MONUMENT ACADEMY Civil Construction Drawings

El Paso County, Colorado

PCD PROJECT NO. PPR-19-009

MONUMENT ACADEMY HIGH SCHOOL

TY2

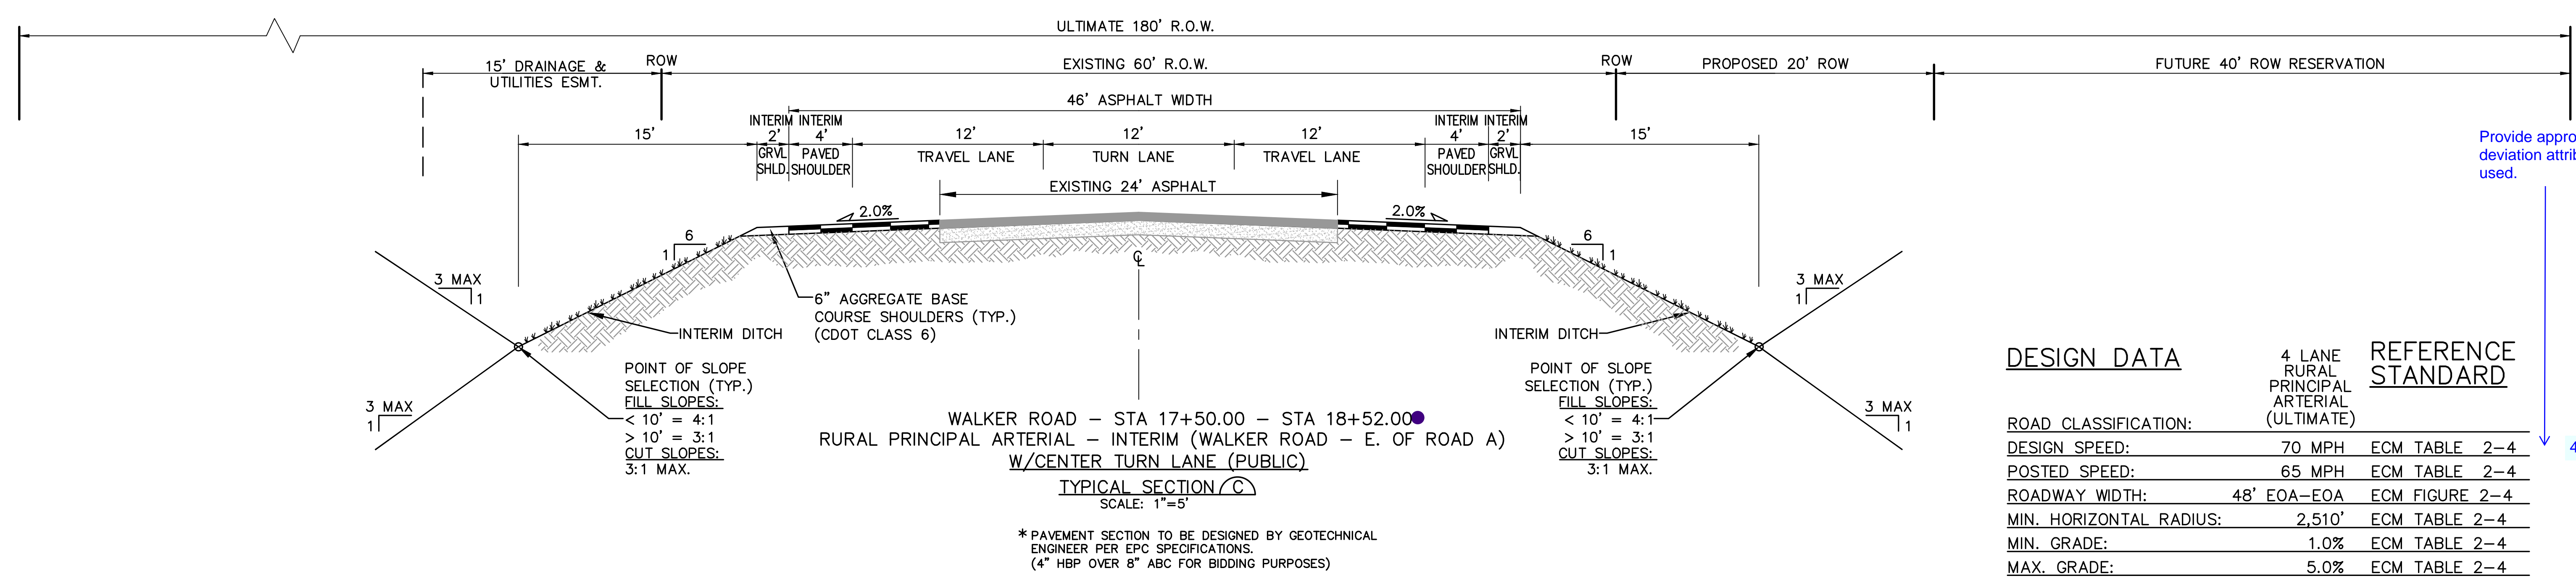
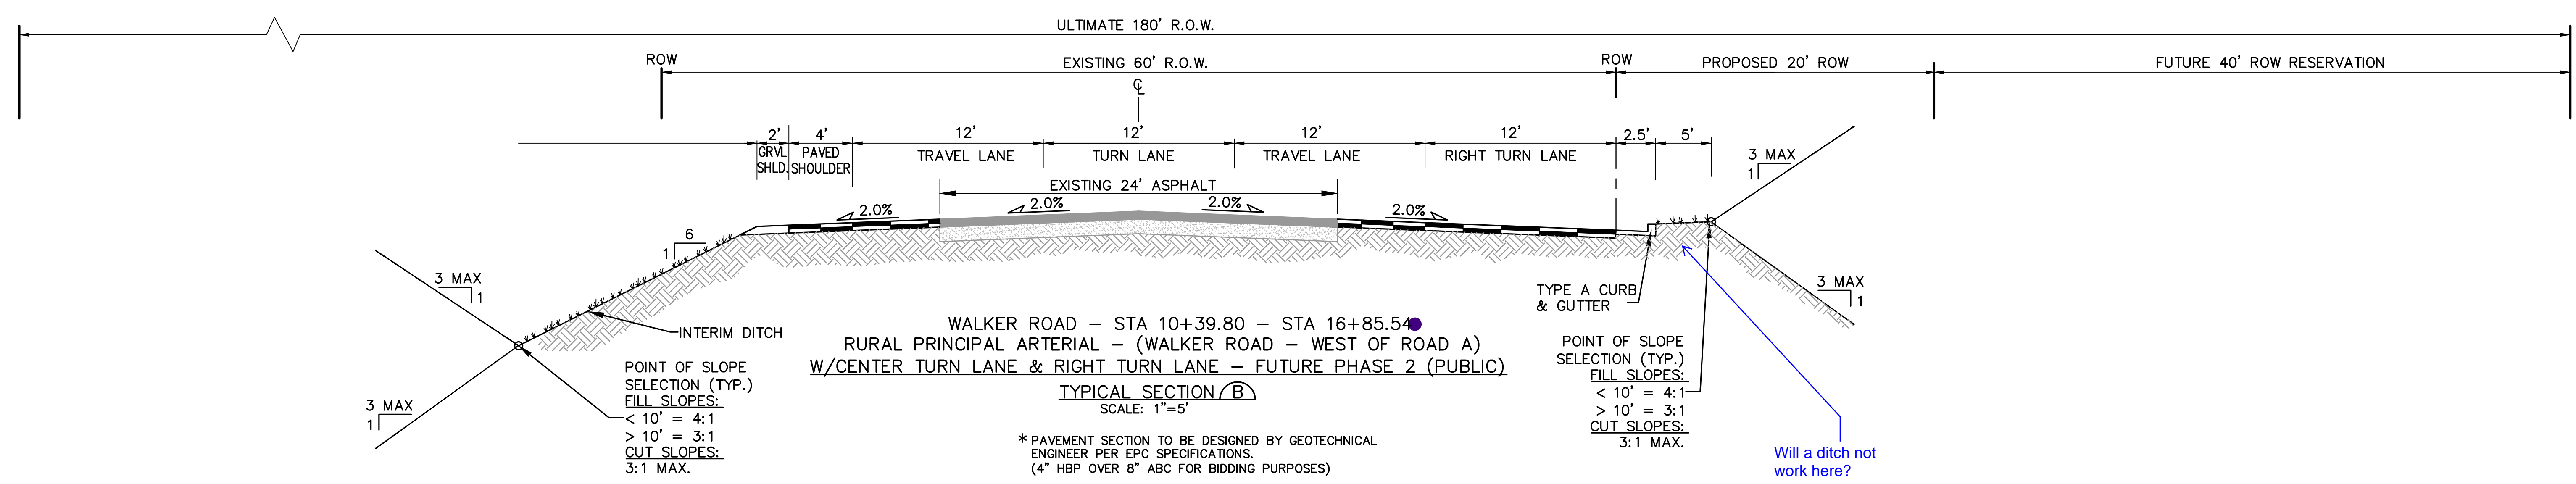
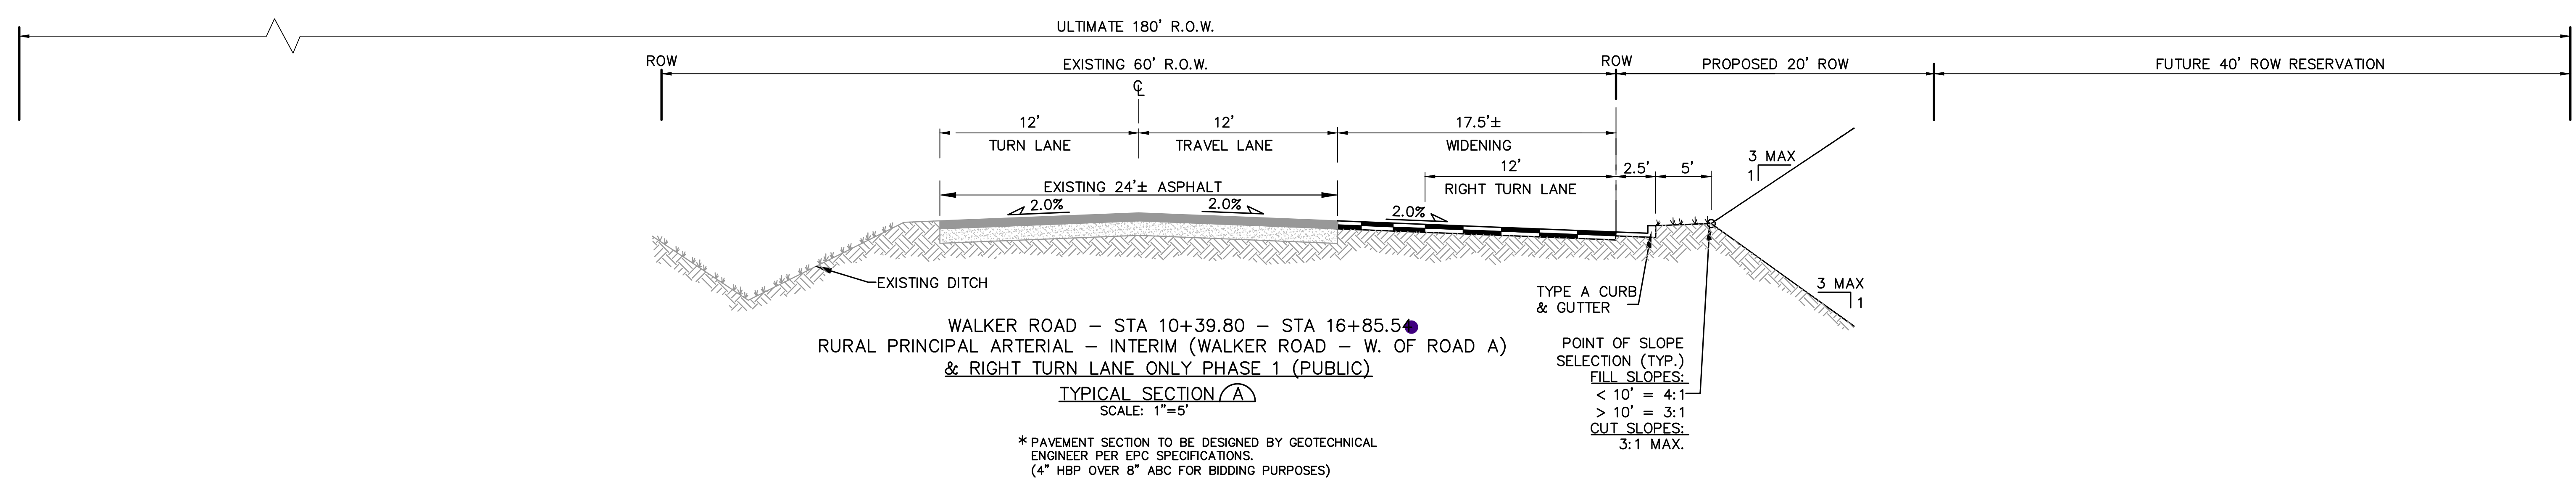
Does this need to be reduced for sight distance?

SCHOOL ACCESS CURB RETURN PROFILES

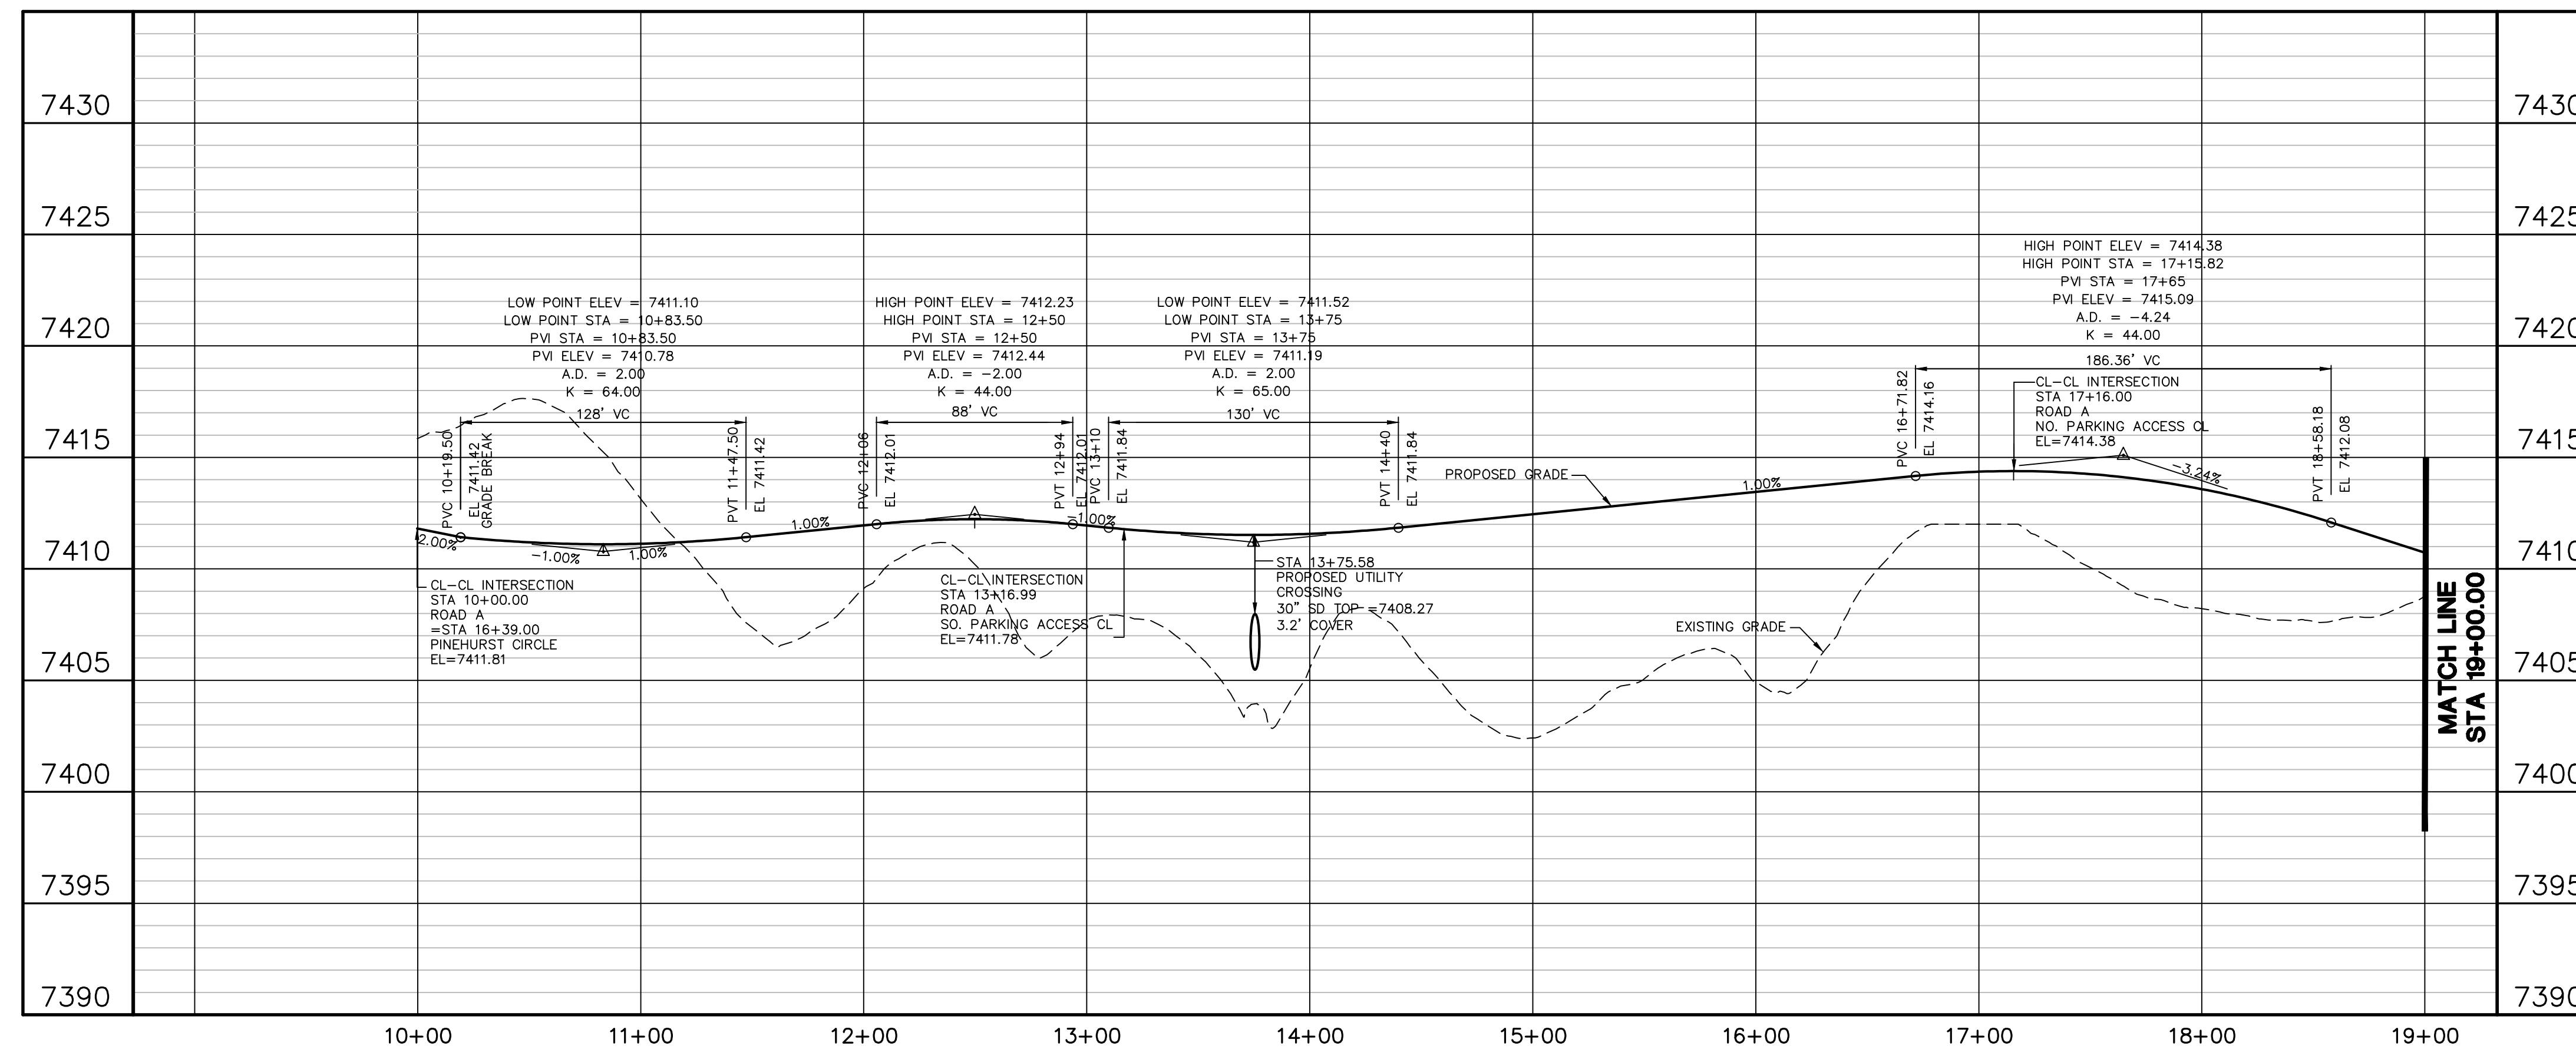
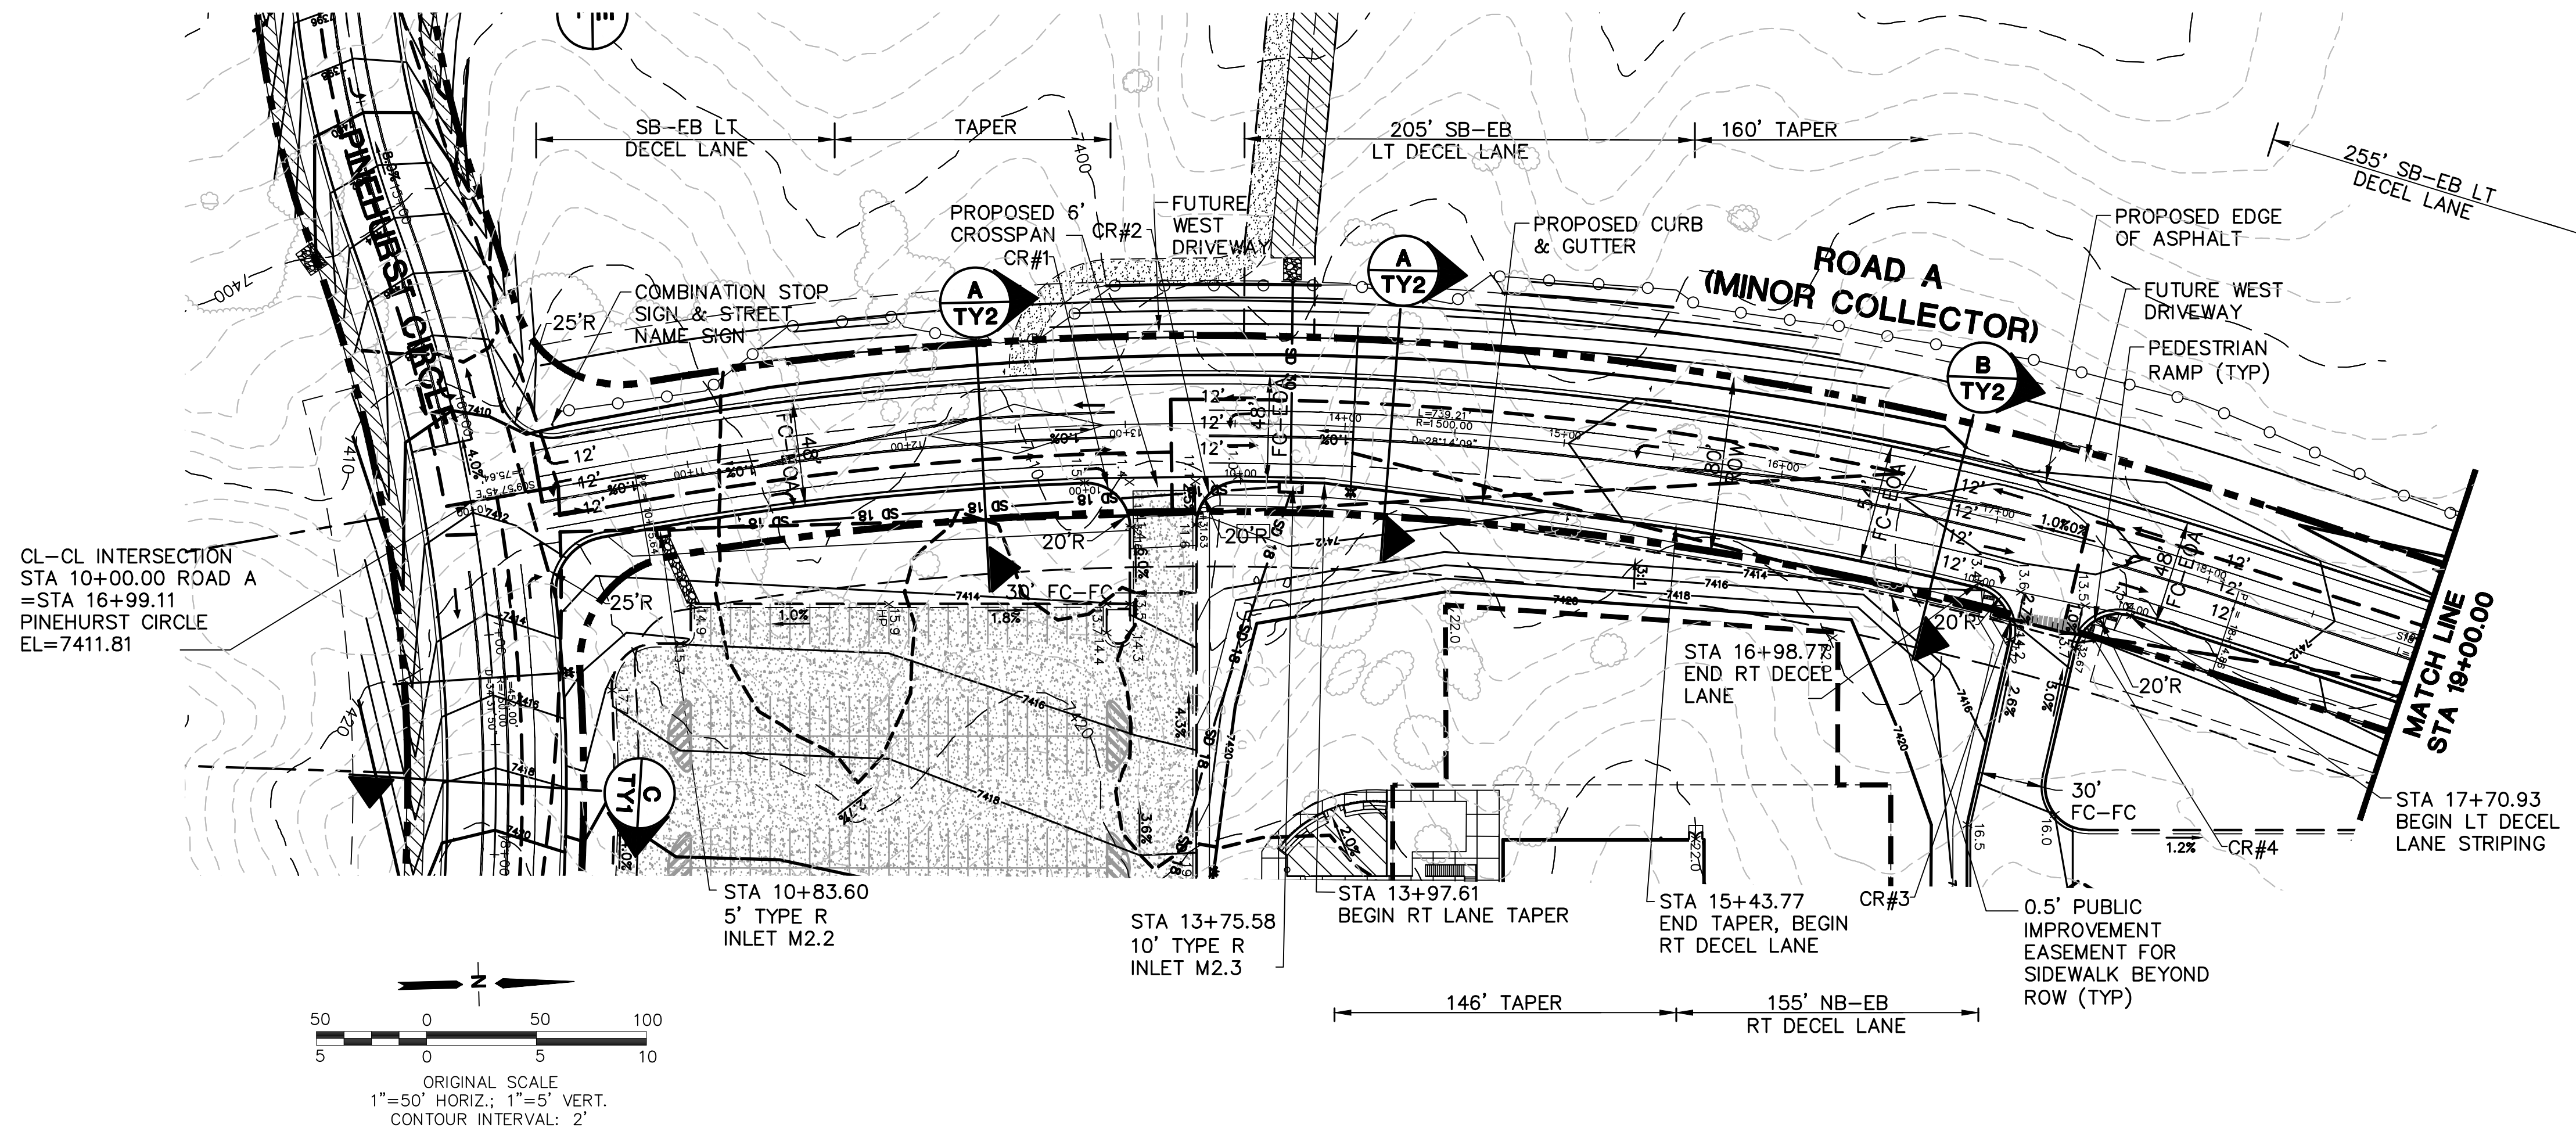
Curb return profiles and detailed pedestrian ramps and crossings are recommended to ensure that ADA requirements are met.
